Tillbridge Solar Project
EN010142

Volume 6
Environmental Statement Addendum
Document Reference: EN010142/APP/6.6

September 2024
Revision Number: 00

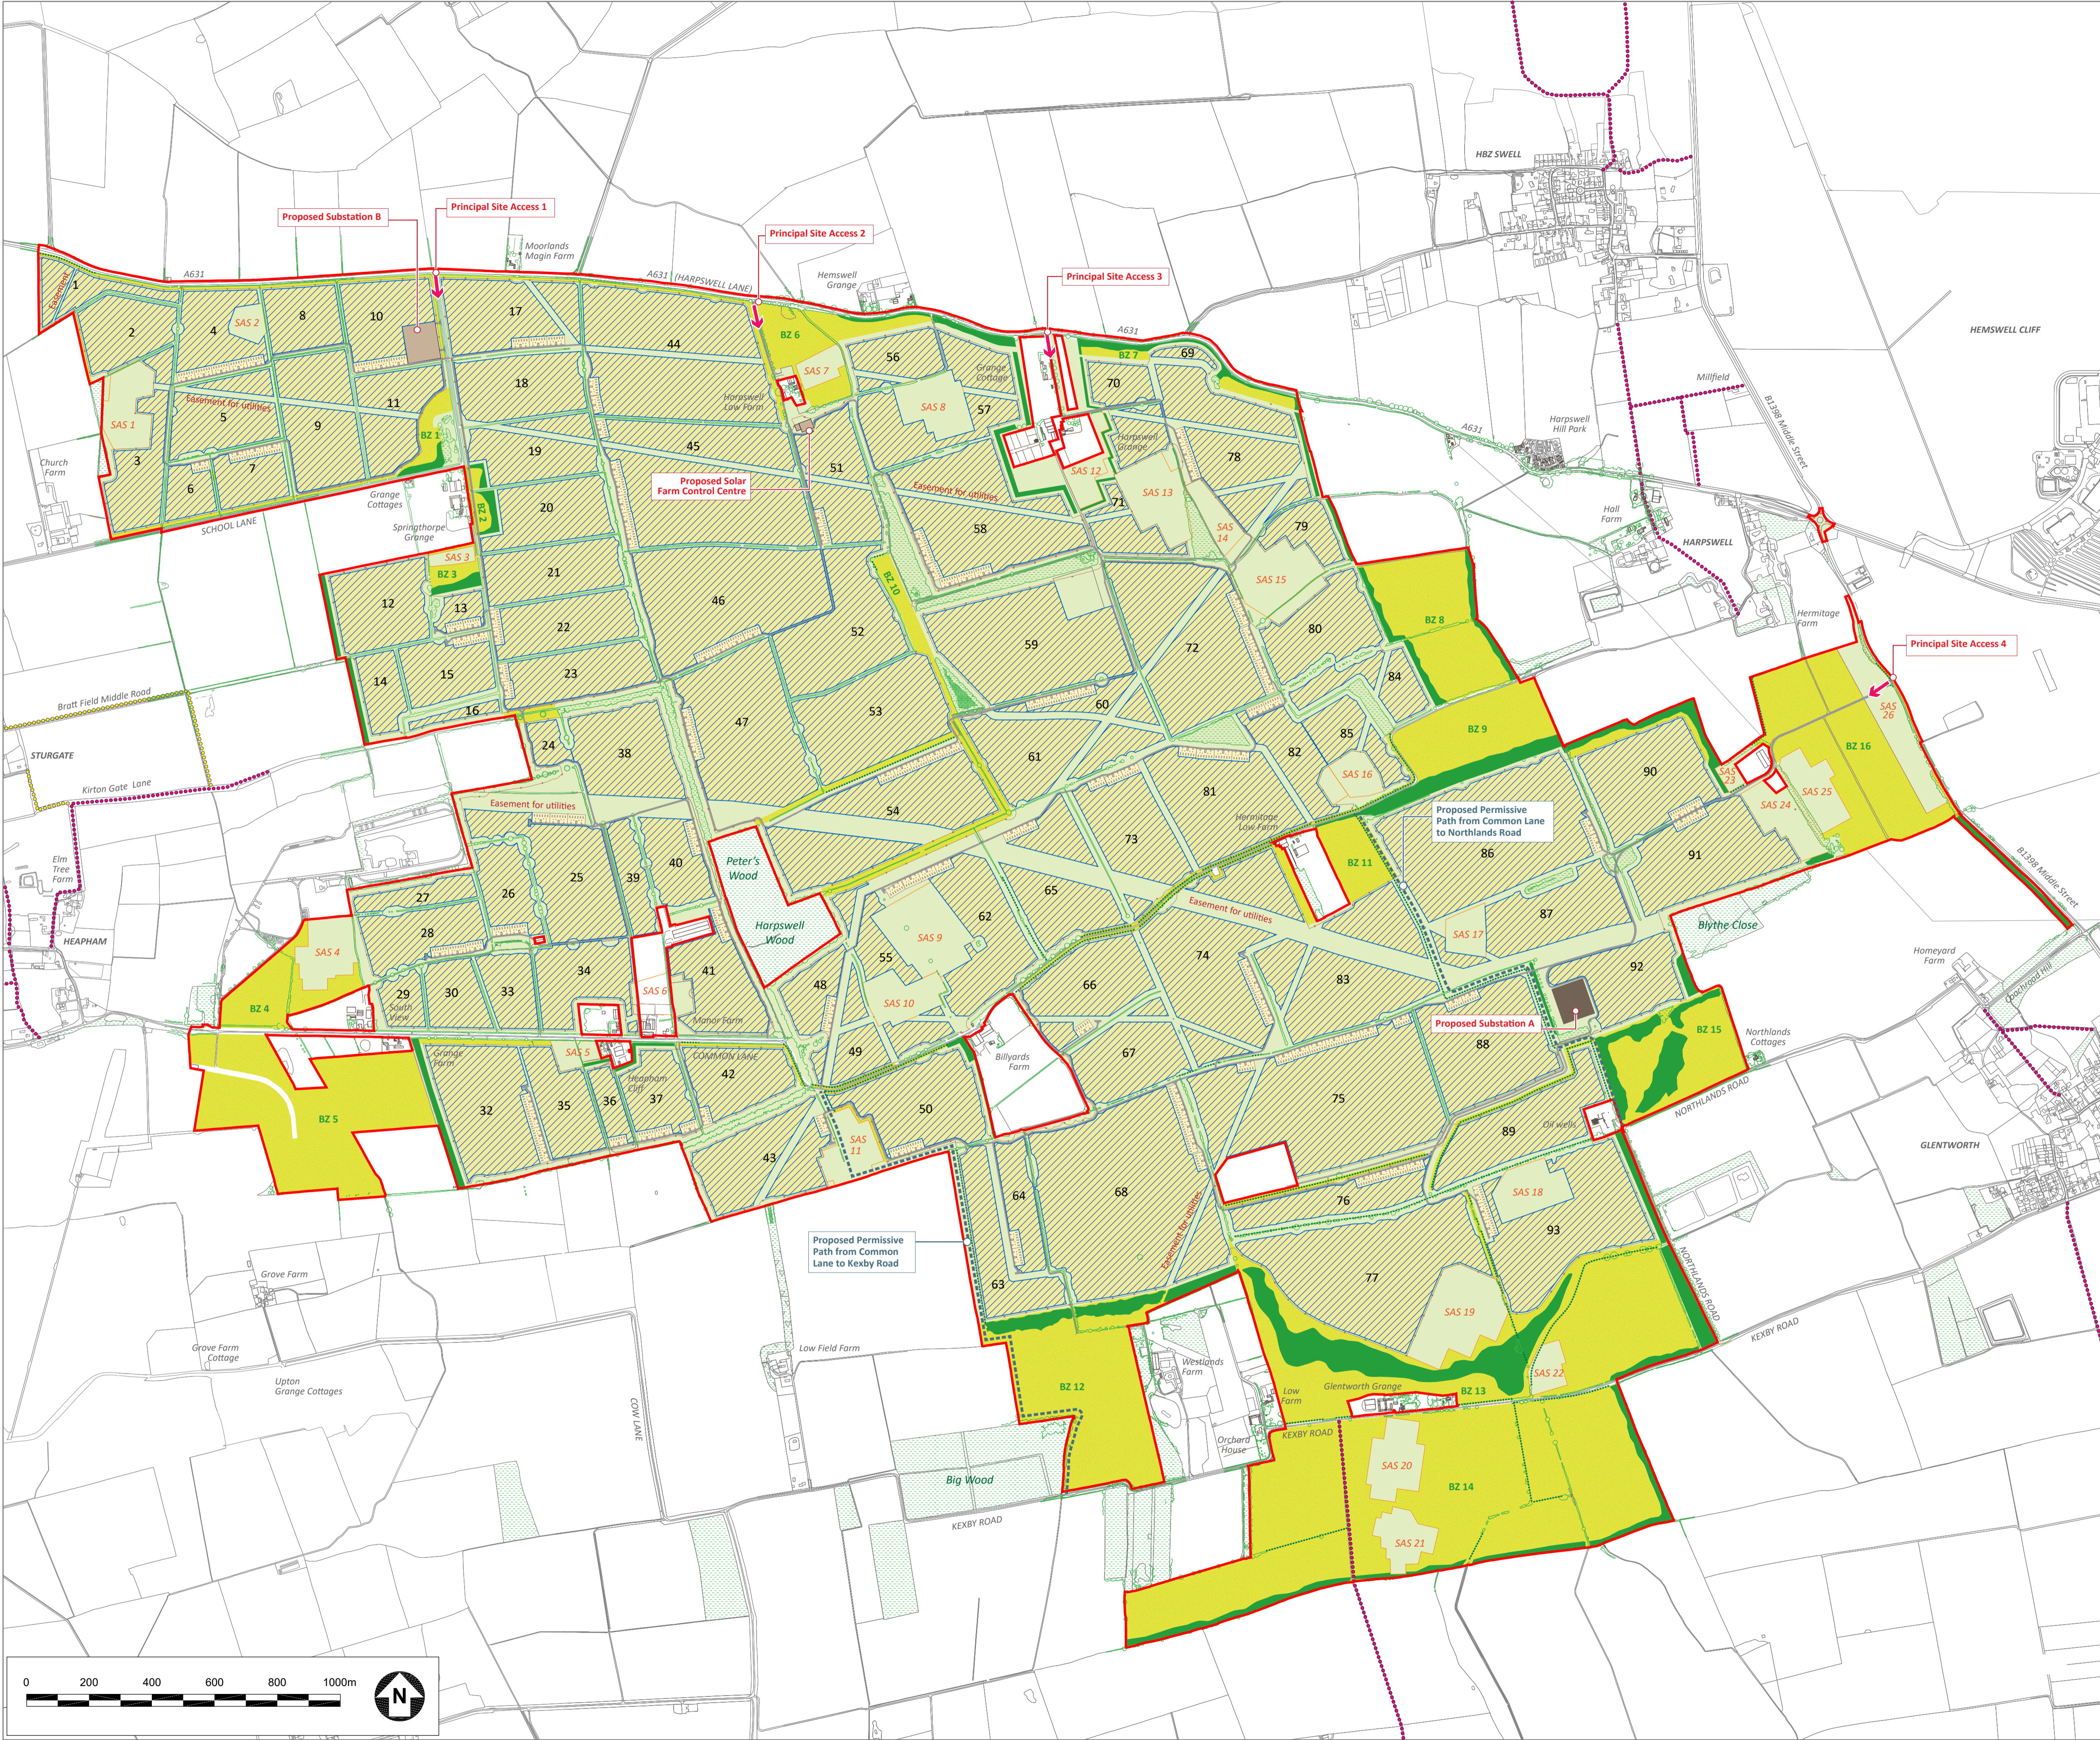
Change 5 would provide two additional internal accesses within the Principal Site. The details of these accesses are provided within the revised **Chapter 3: Scheme**

Description [EN010142/APP/6.1(Rev 01)] and presented on the revised **Figure 3-1: Indicative Principal Site Layout** and **Figure 3-7: Access Locations [EN010142/APP/6.3(Rev 01)]**.

Change 11 would remove an area of land from two SASs. SAS23 and SAS24 and the indicative landscaping proposals are revised in these locations. The removal of part of the SAS areas does not mean archaeology will be any less protected or that there will be any worse effects as a result of the Scheme, as the relevant areas will be excluded from the Order limits, with no effect on these areas. Change 11 does not introduce any significant changes to the assessment and as such, there are no new or different effects with regards to cultural heritage as described in **Chapter 8: Cultural Heritage** of the ES [APP-039].
